Subject: FW: AB/112/21/DOC (Canada Road)

Subject: RE: AB/112/21/DOC (Canada Road)

Further comments following my consultation dated 27th September 2021 (item numbers referenced as previous) and their engineers response (enclosed);

TYPICAL ACCESS CHAMBER DETAIL - TYPE 3
(Scale 1:20)

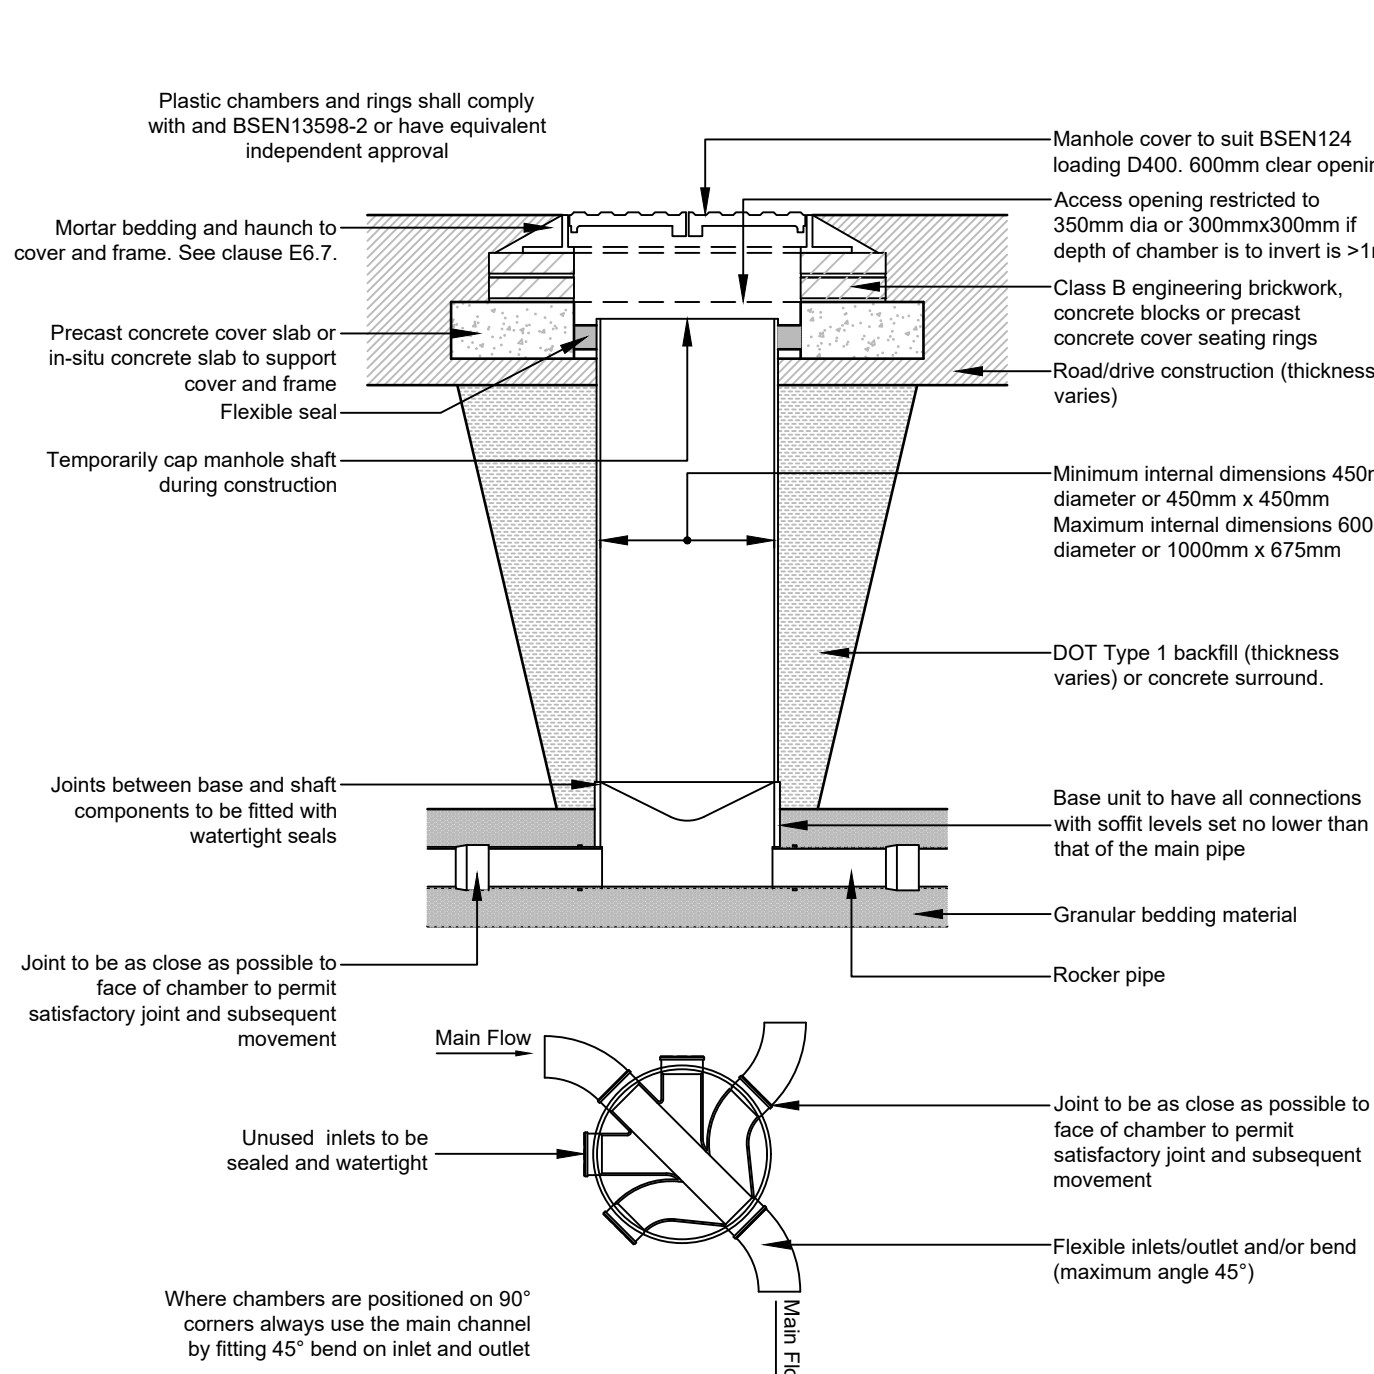
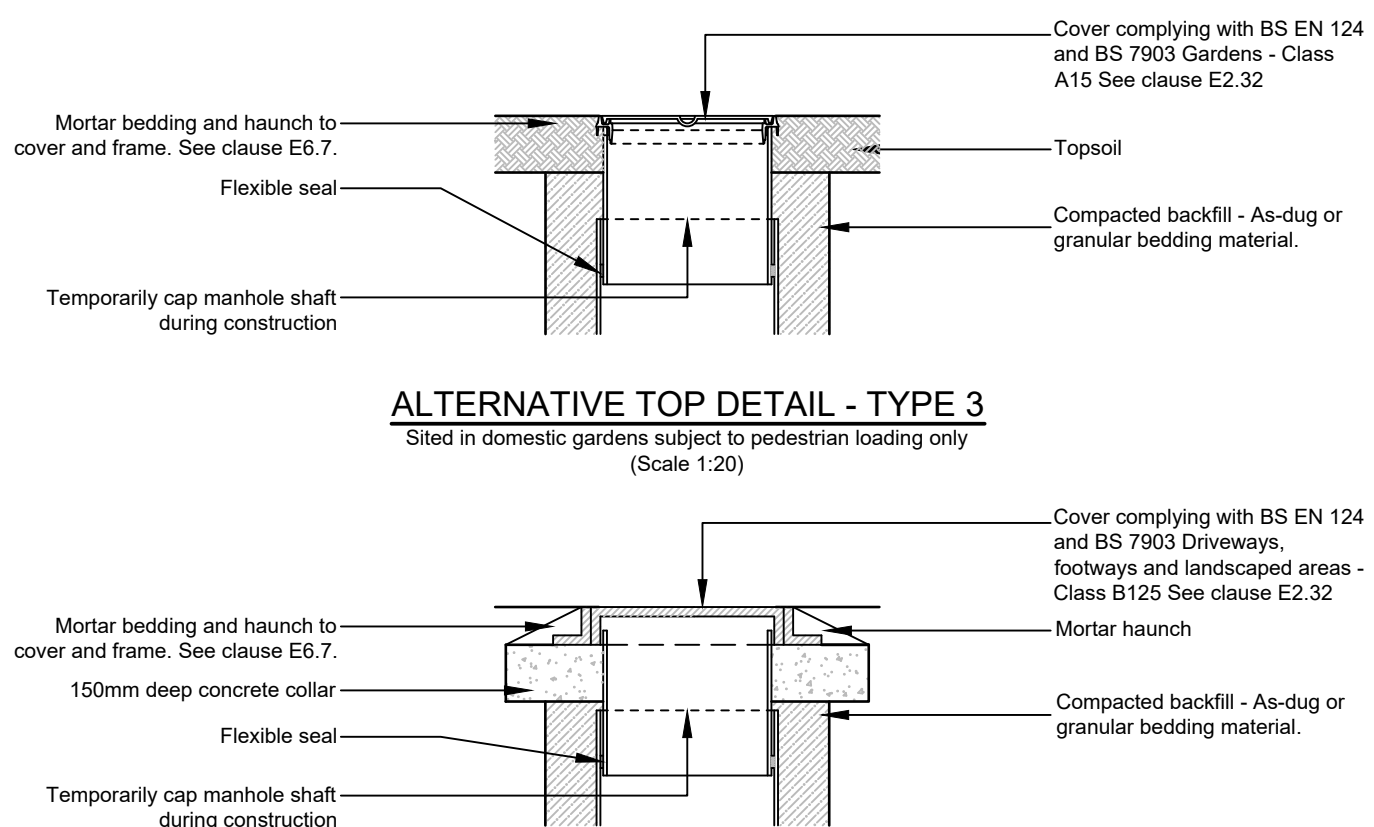
- a) Ok.
- b) Please specifically mention ductile iron covers and frames including opening dimensions (for the contractors benefit).
- c) Please specifically mention ductile iron covers and frames including opening dimensions (for the contractors benefit). If a formal overflow is to be provided then its level needs to be set above the predicted 1 in 100 year +40% flood level (indicate invert level). A better option may be to introduce a grated cover and use that as the overflow for events exceeding the 1 in 100 year + 40%, taking account of item 6 above. Specify sump dimensions based upon the hydrobrake manufacturers recommendations. Specify hydrobrake model. Indicate base thickness/ring surround thickness. Fully specify step rungs (not shown but required)/all concrete components including benching, rings, cover slab, mounting block, etc.

TYPICAL CATCHPIT DETAIL (1200Ø)
(Scale 1:20)

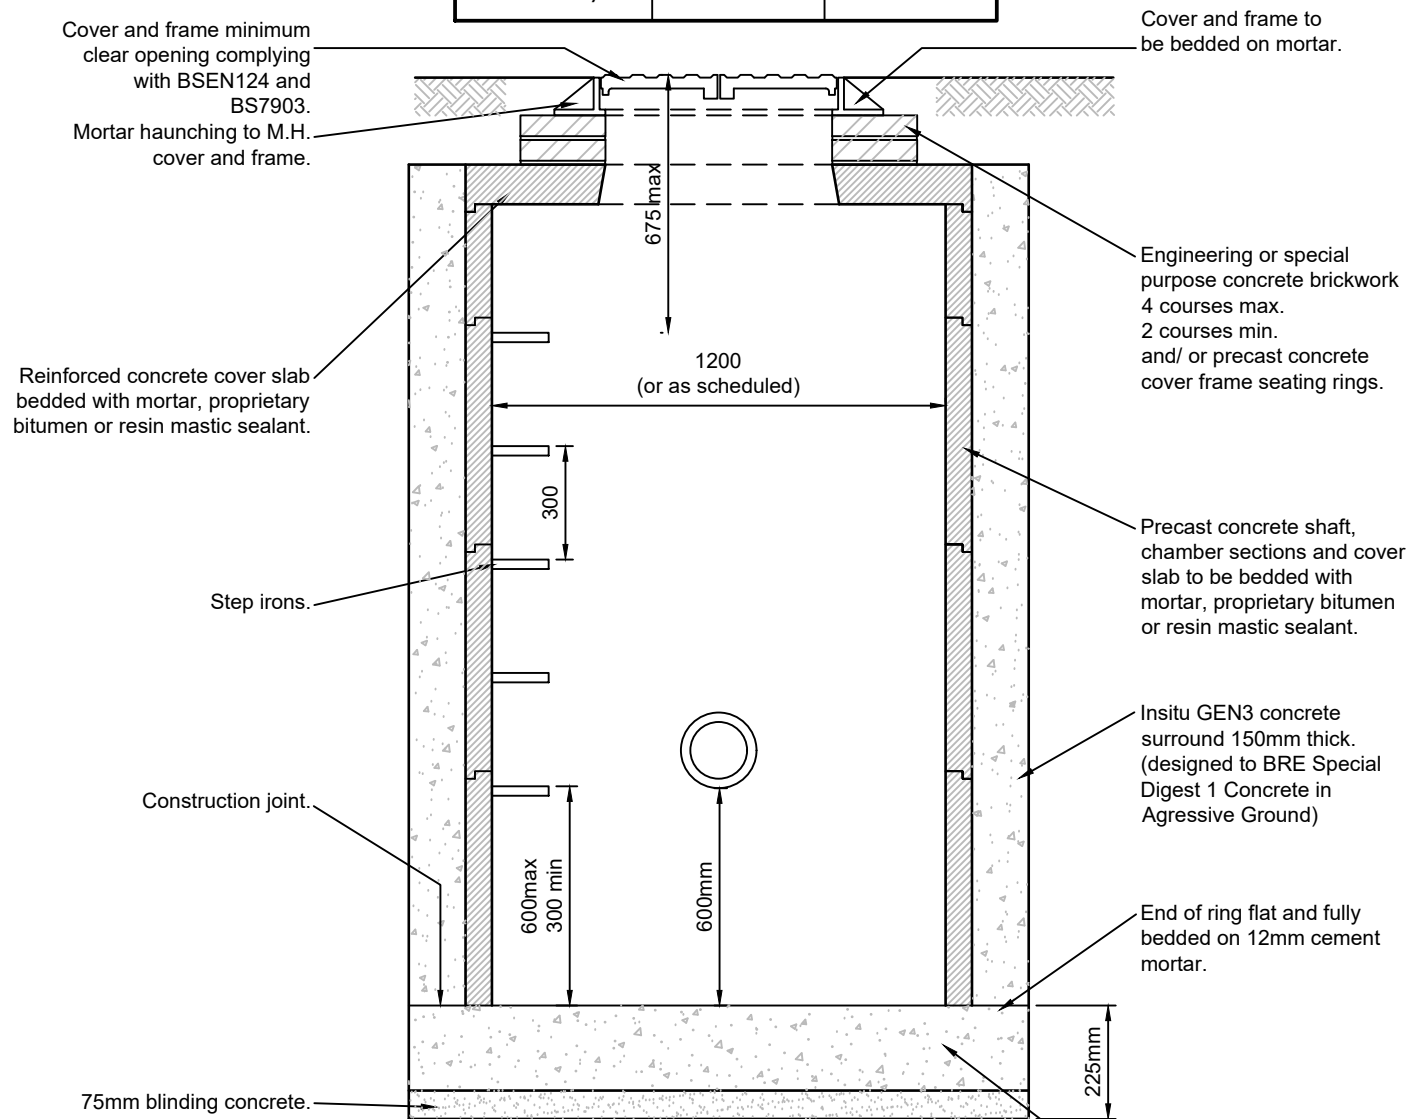
Item 1.2.3 – refer to catchpits mentioned subsequently rather than previously.

Item 1.4.1 – inlet/outfall section not relevant in this case? Desilting catchpits, gullies etc to be an annual event (minimum). Specifically mention the channel drain. Inspection items to be monthly for first 3 months, then annual. Include hydrobrake manufacturers maintenance regime. Include periodic inspection of pipework ie. CCTV survey, say every 5 years.
